TECHNICAL NOTE

Former Nestle Factory, Hayes

Response to LBH Transport Comments

14th August 2017

CYCLES PARKING LAYOUT - GROUND FLOOR PLAN

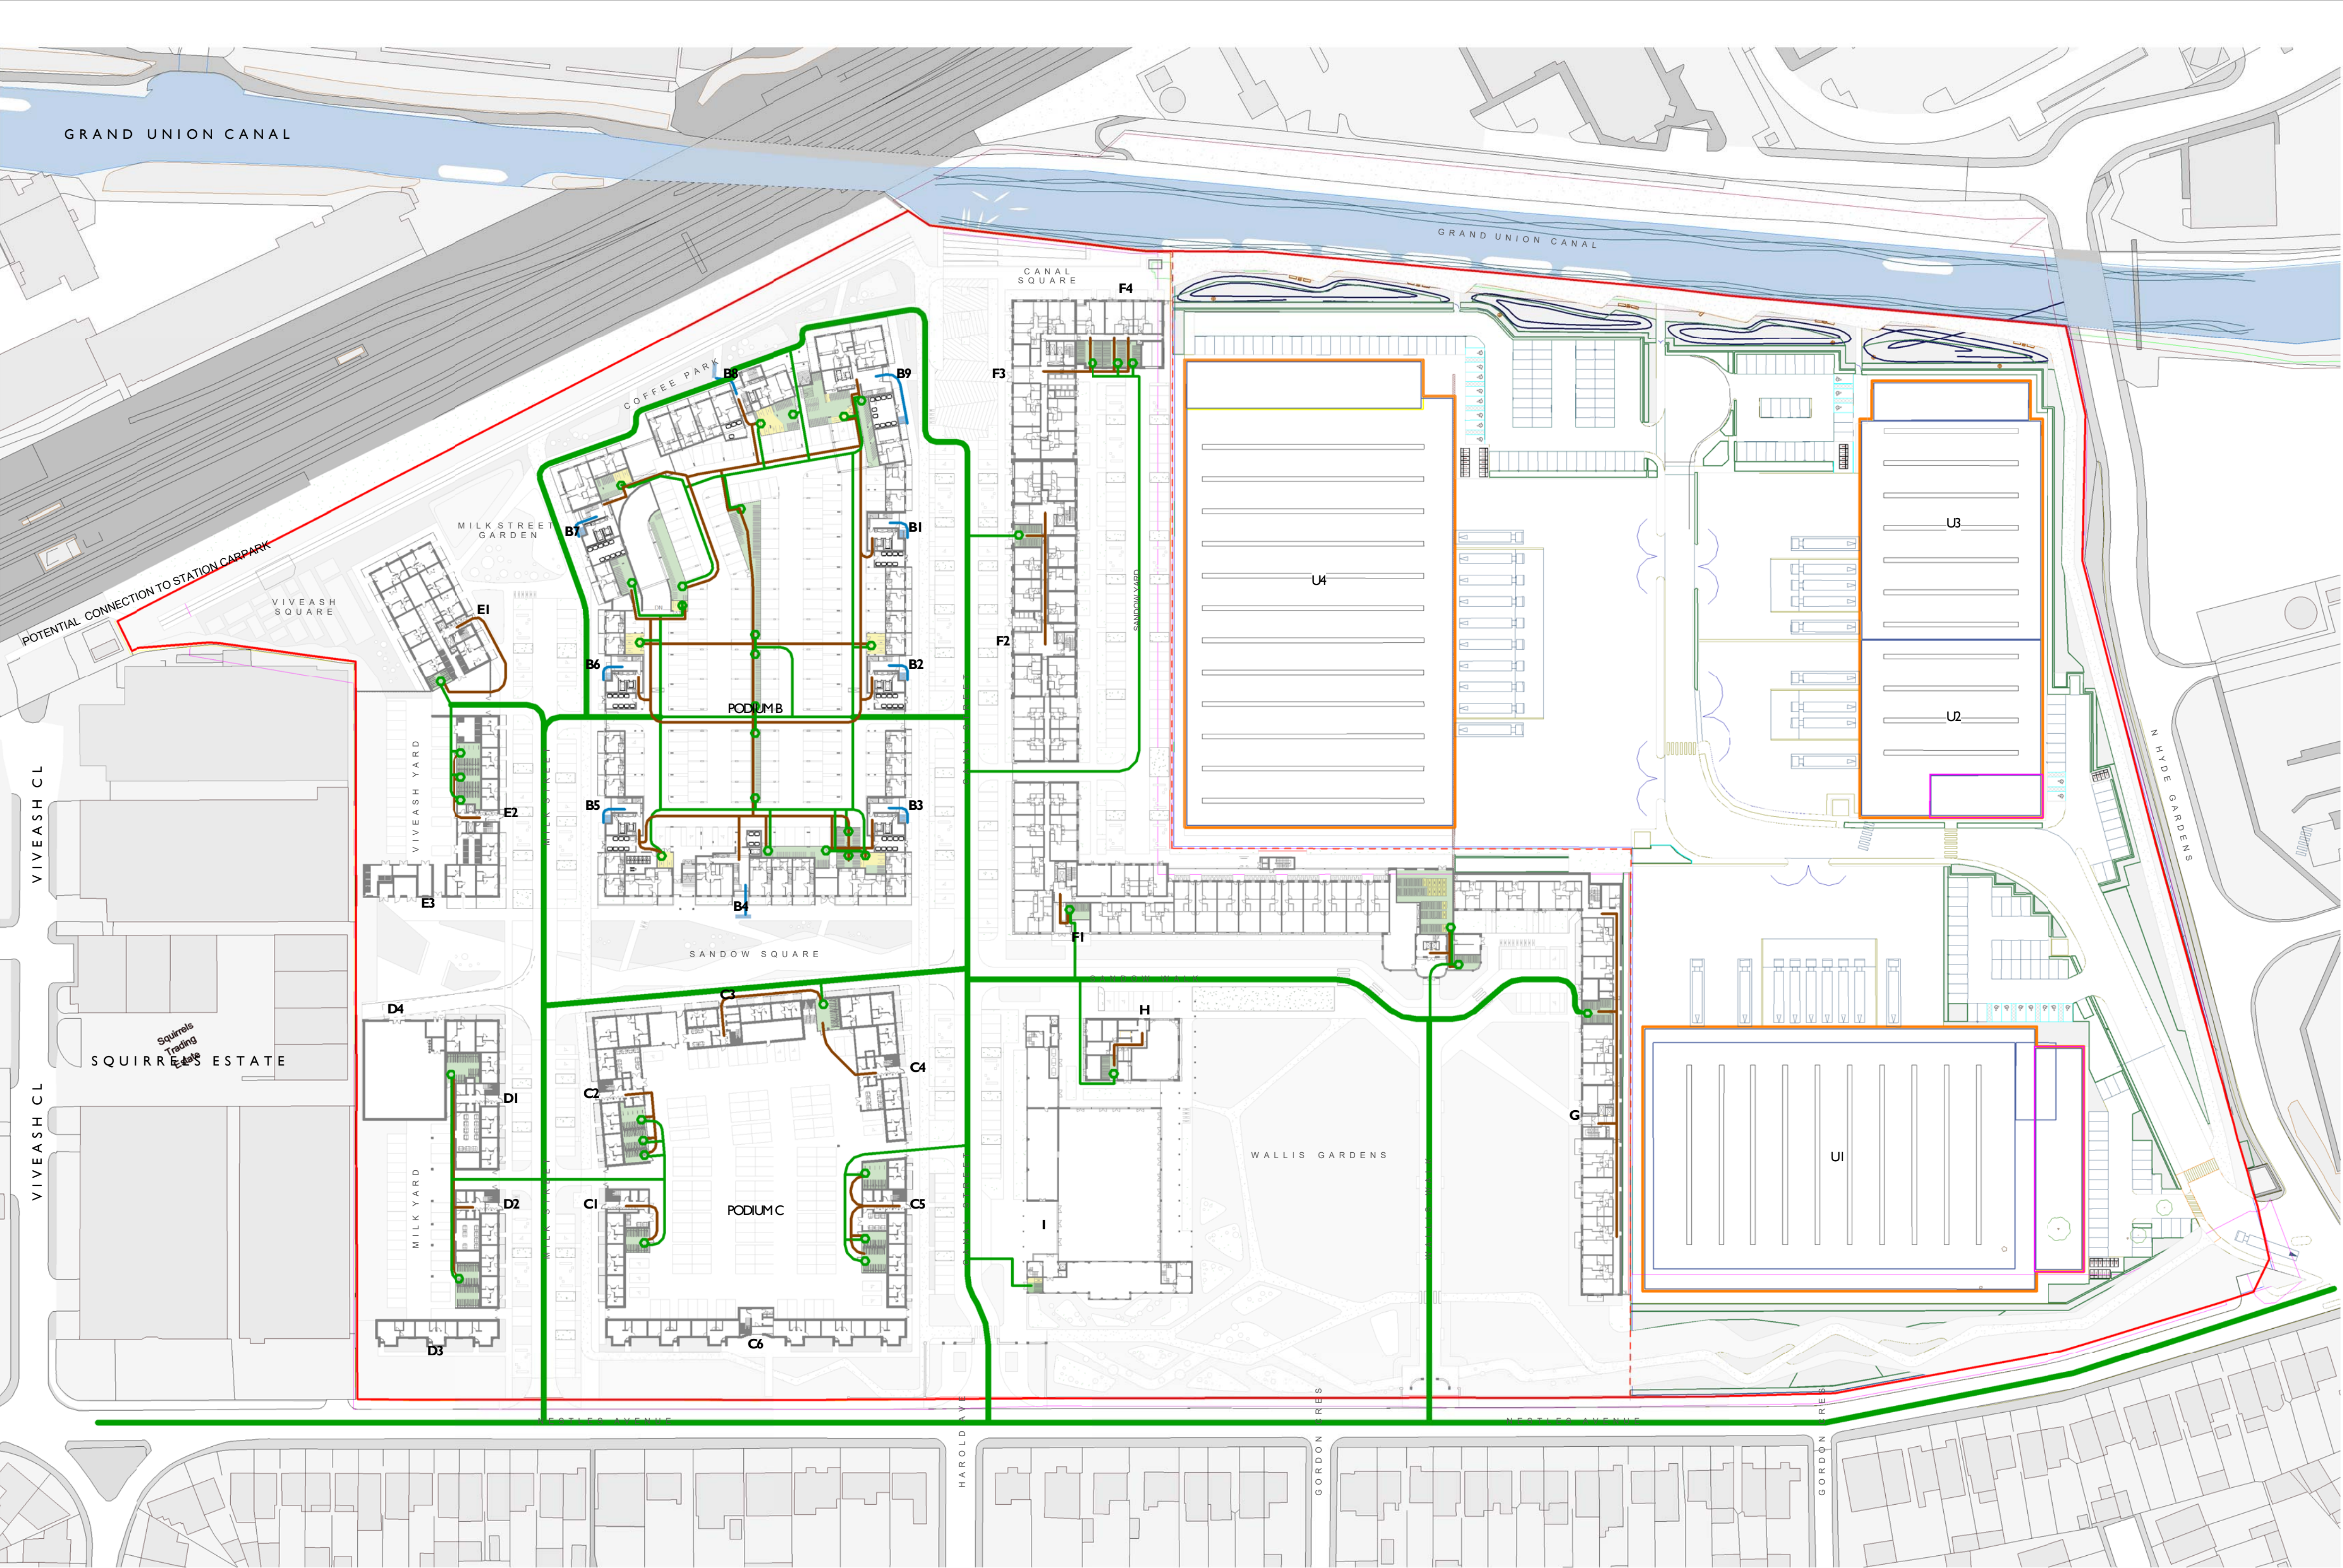
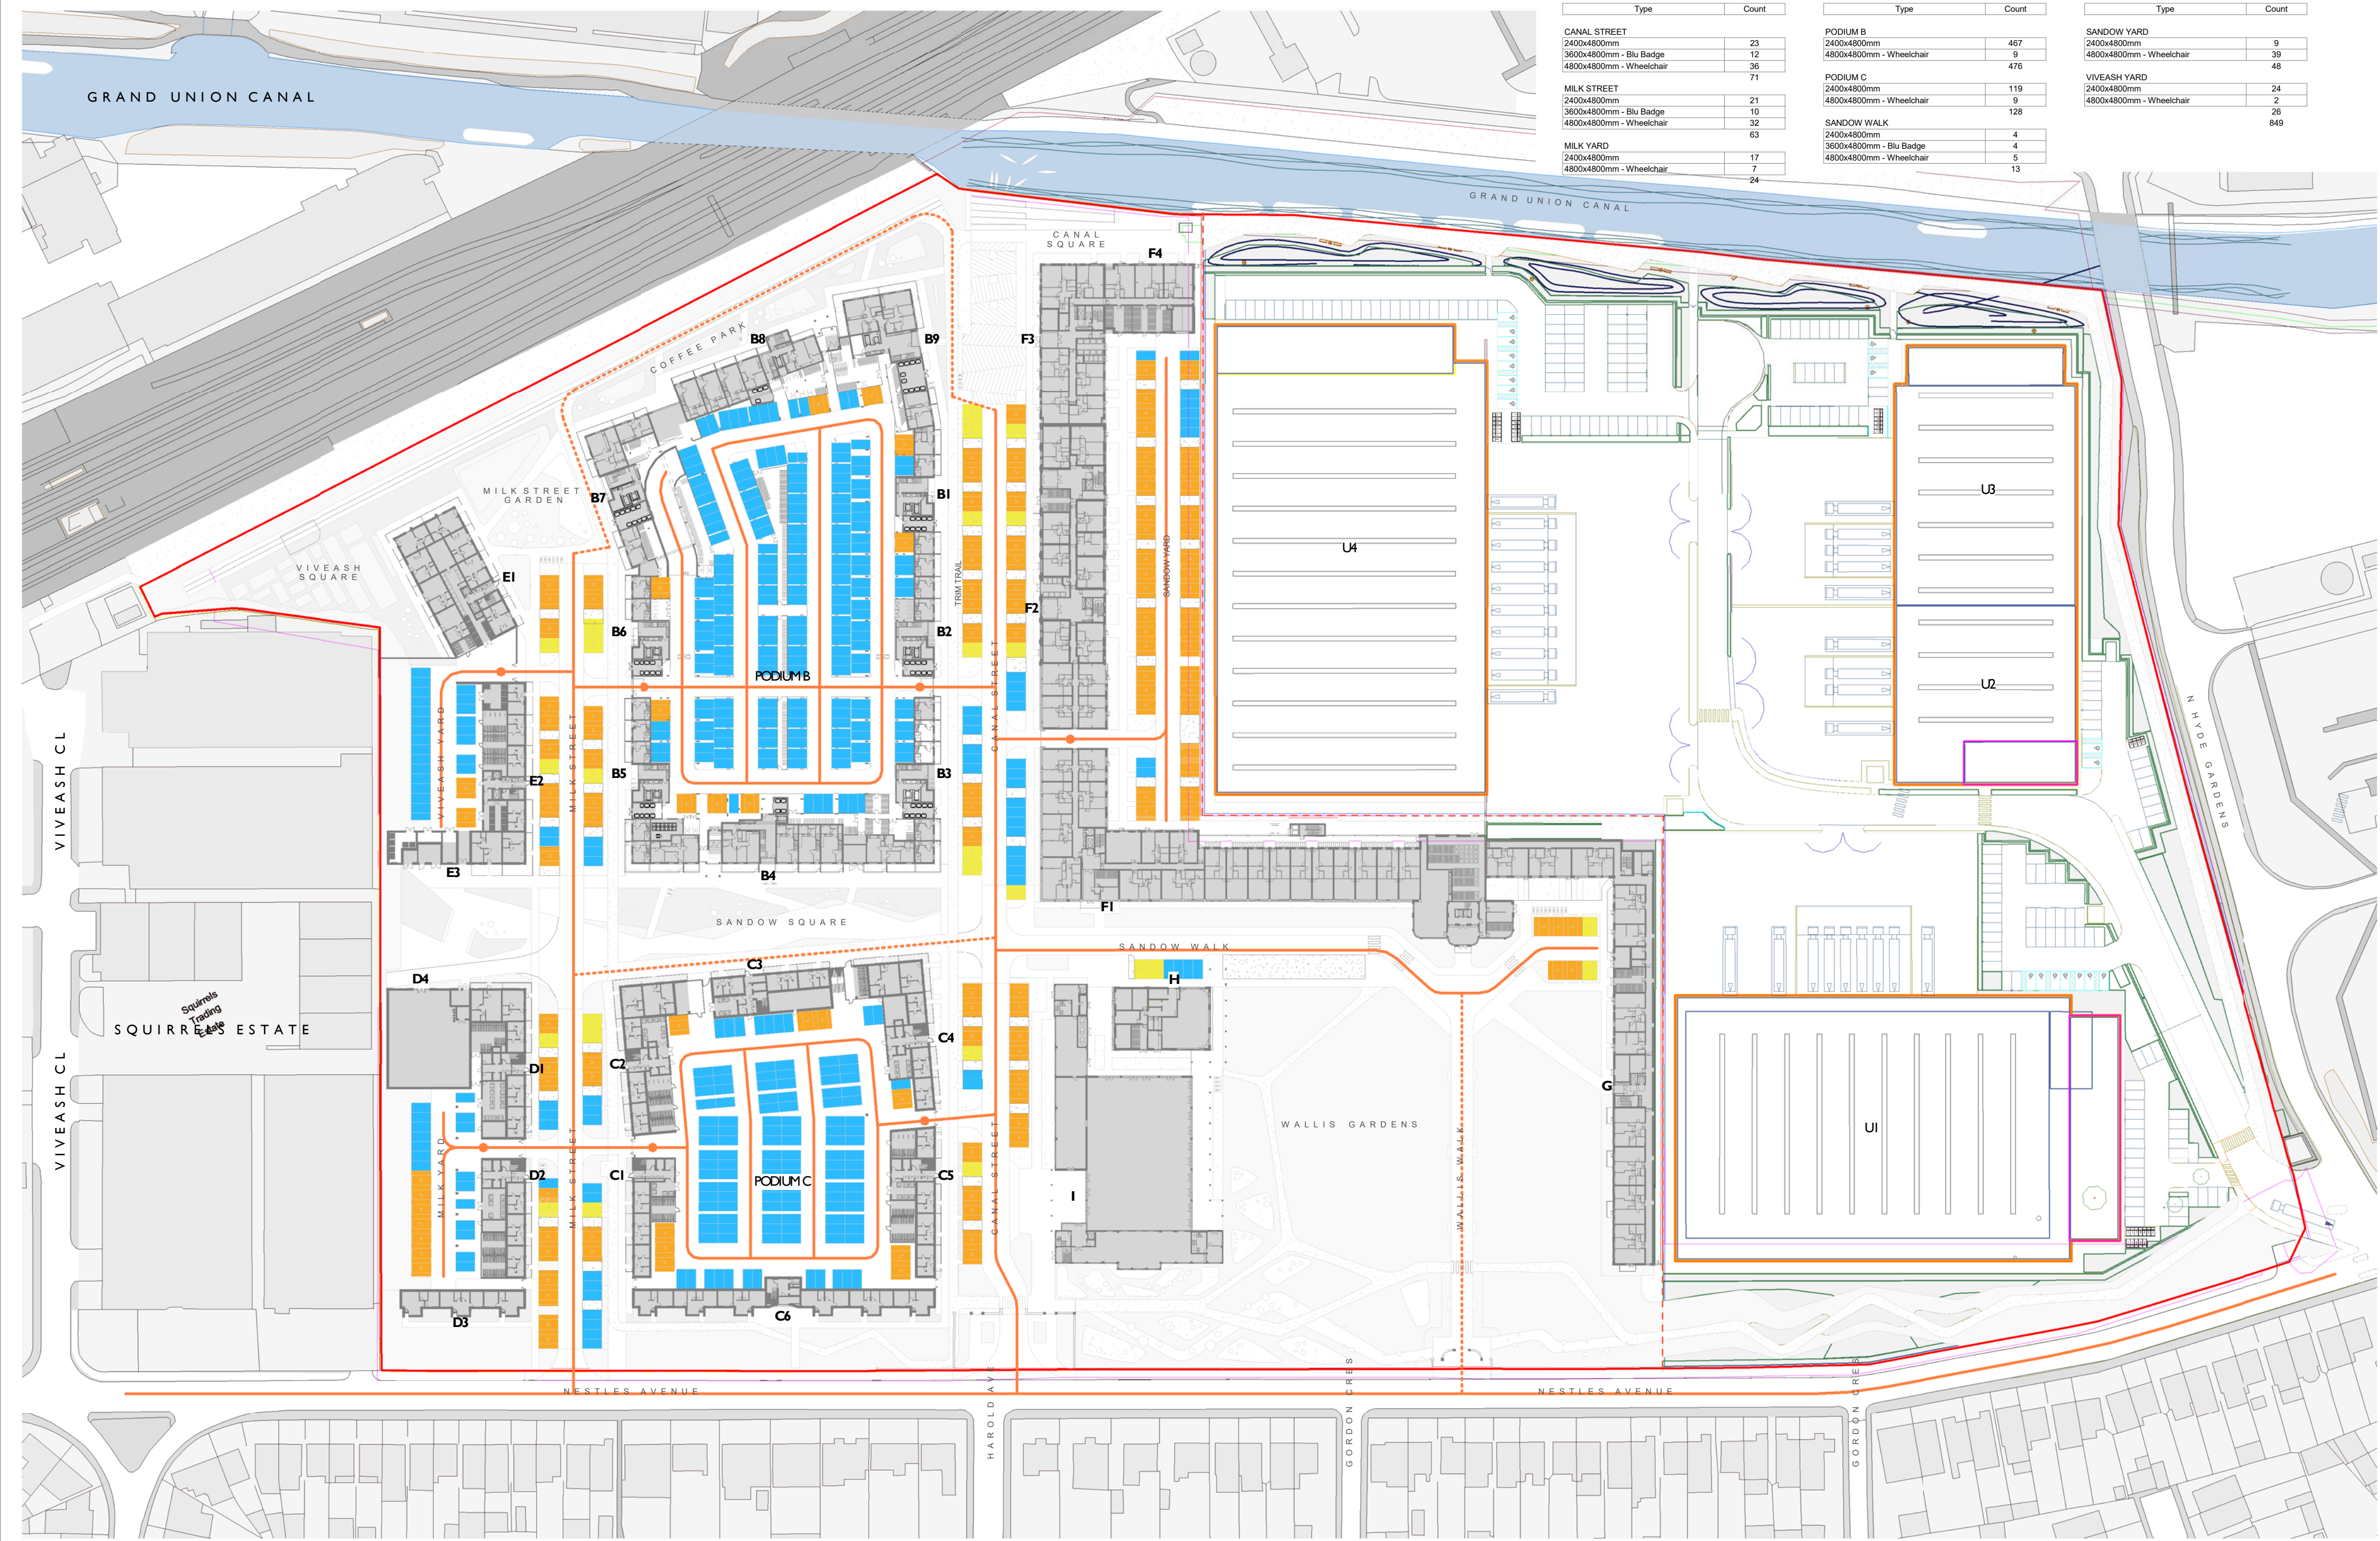
11.4 Further details are requested on the type and location of cycle parking for the proposals. It is intended that residential cycle parking provision is a mix of stacked stands (Josta type or similar) and larger stands of Sheffield type. Drawing No MP 721 submitted with the application identifies cycle parking locations and routes to access them. More detail of the cycle parking layouts for specific blocks can be seen in the following Drawings:
